REQUEST

Proposed Zoning: R-12MF(CD) SPA (Multi-Family Residential, Conditional, Site Plan Amendment)

Approximately 42.85 acres located on the south side of Pineville-Matthews Road, east of Hugh Forest Road, and west of Reverdy Lane.

The petition proposes to redevelop 66 of the existing 266 multi-family dwelling units on the western portion of the site with **278** ~~300~~ new units for a total of **478** ~~500~~ dwelling units on the site located in southeast Charlotte.

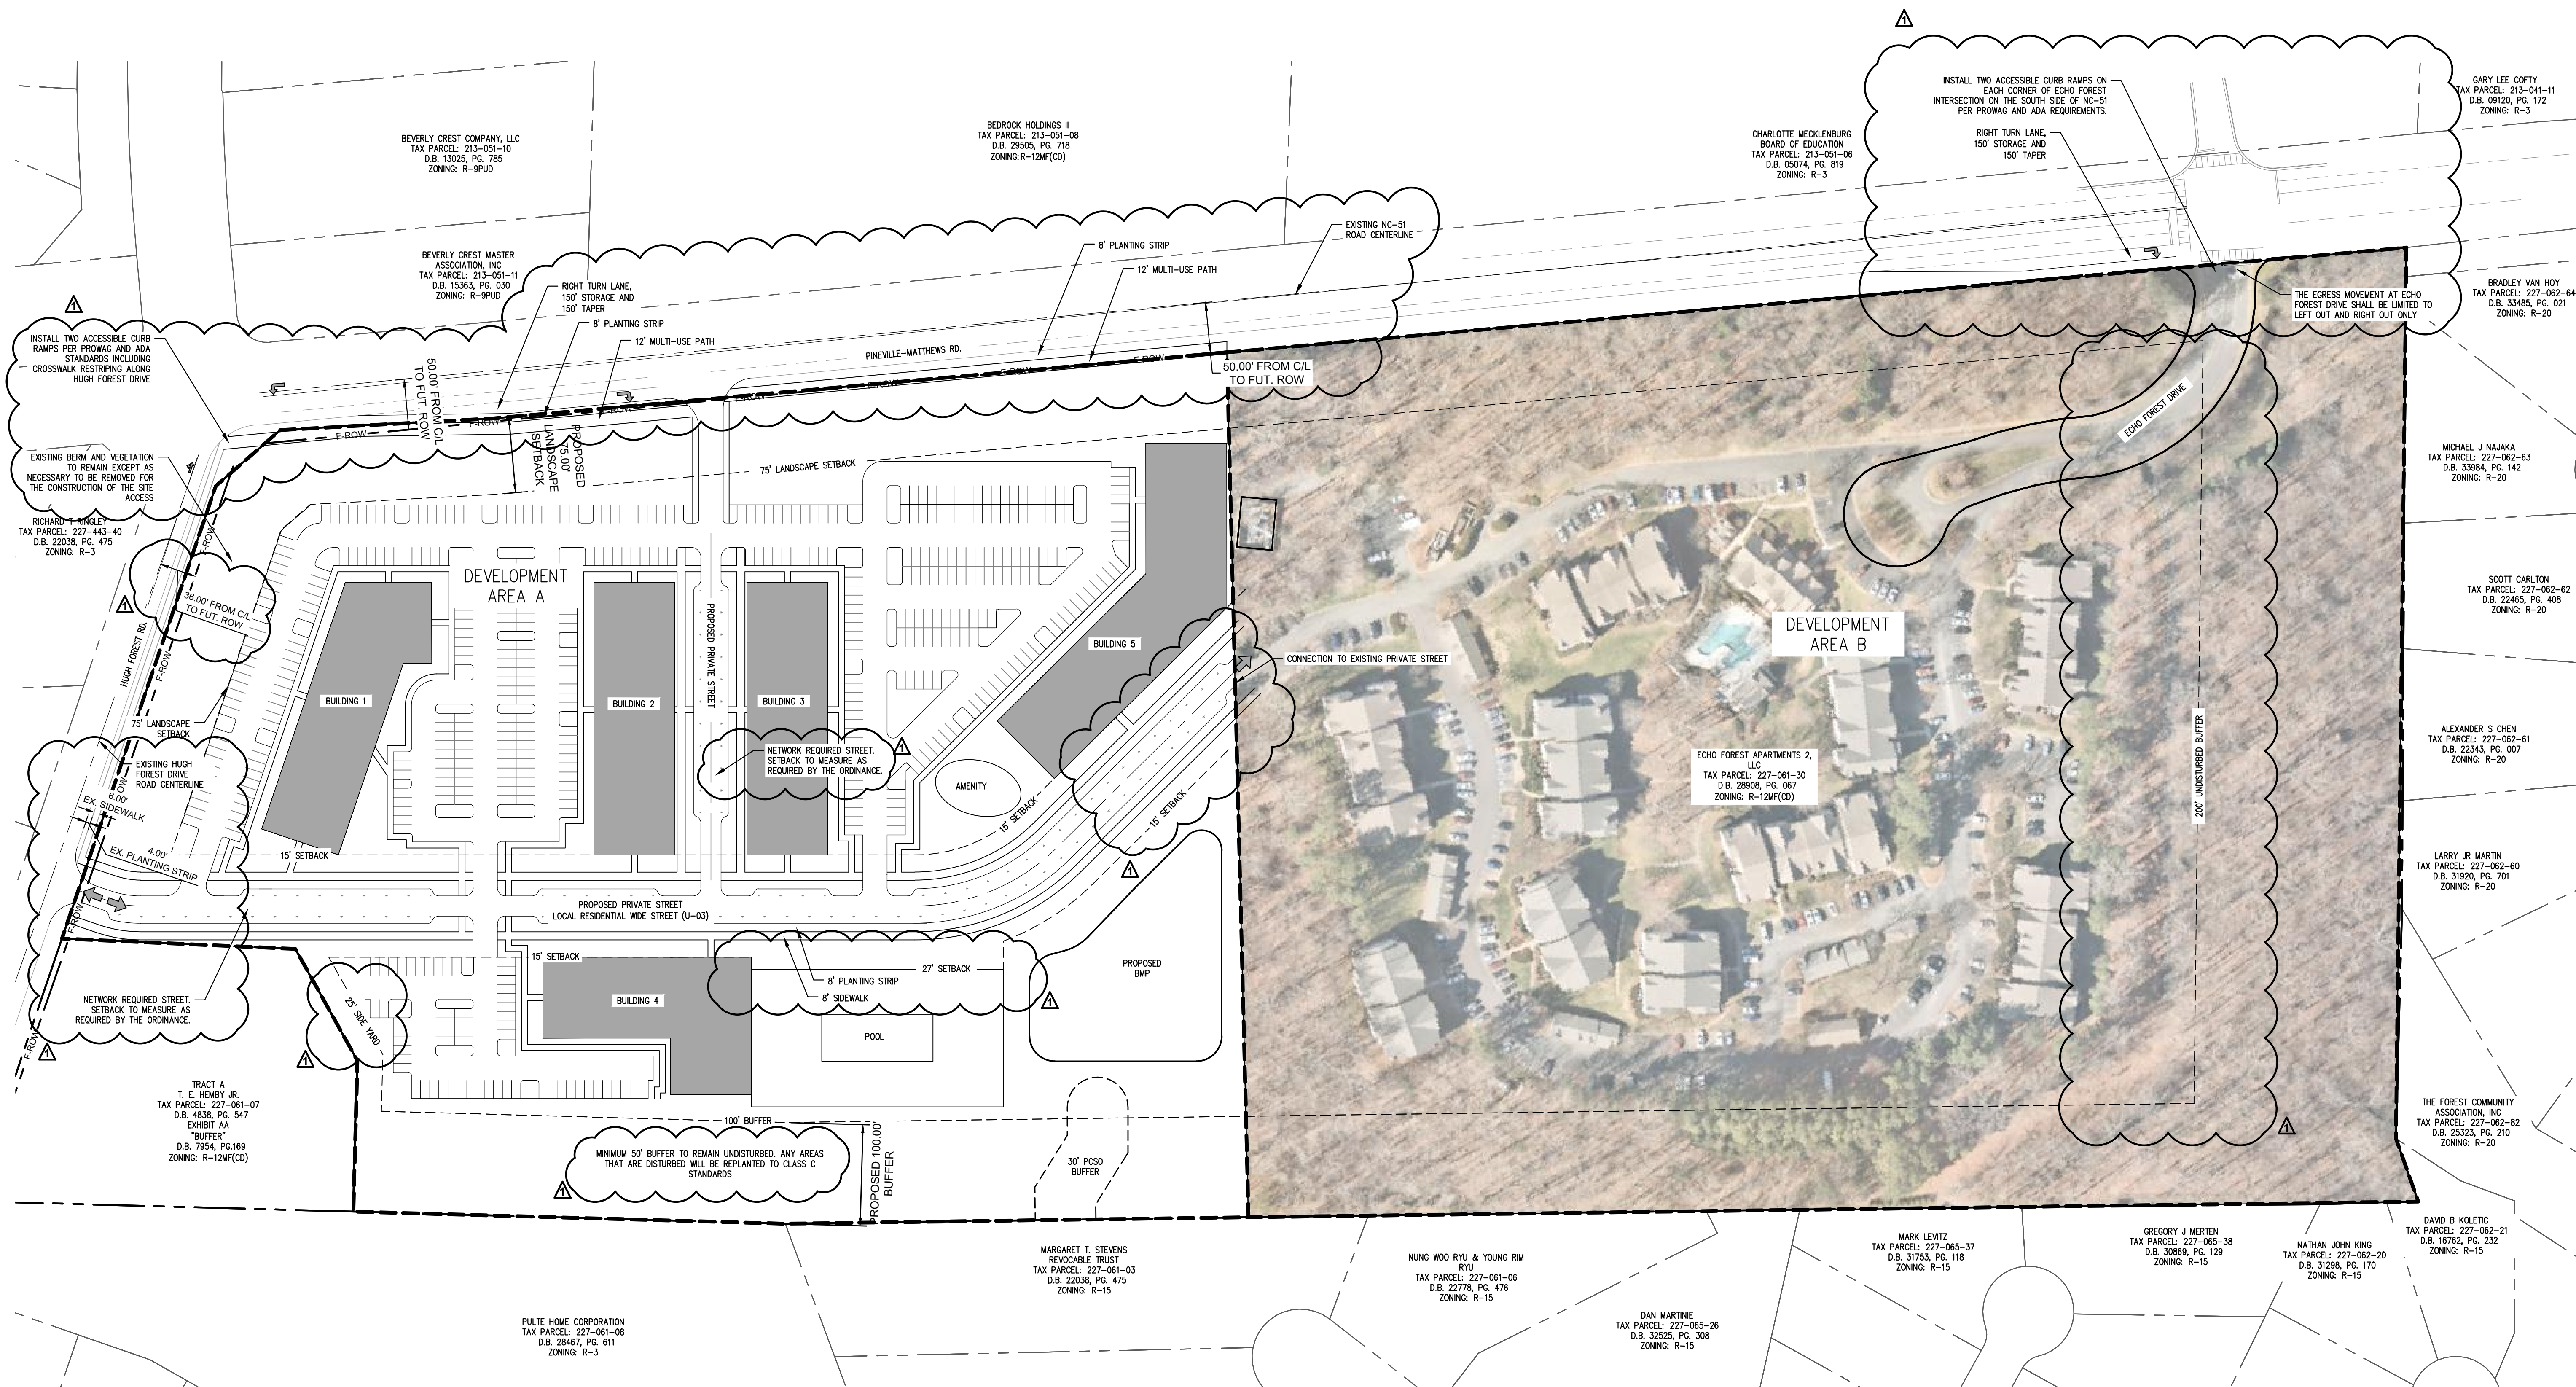
2. ~~Amend the label on the site cross section from "existing road" to "Existing Hugh Forest Road"~~ Addressed
3. ~~Clarify proposed improved open space adjacent to MUP in note 6b is in addition to the minimum 10,000 square feet in noted 6a.~~ Addressed

4. ~~Update identified mitigation figure on page 1 of the site plan to the one from the approved TTM. The figure shown is from the old TTM.~~ Addressed
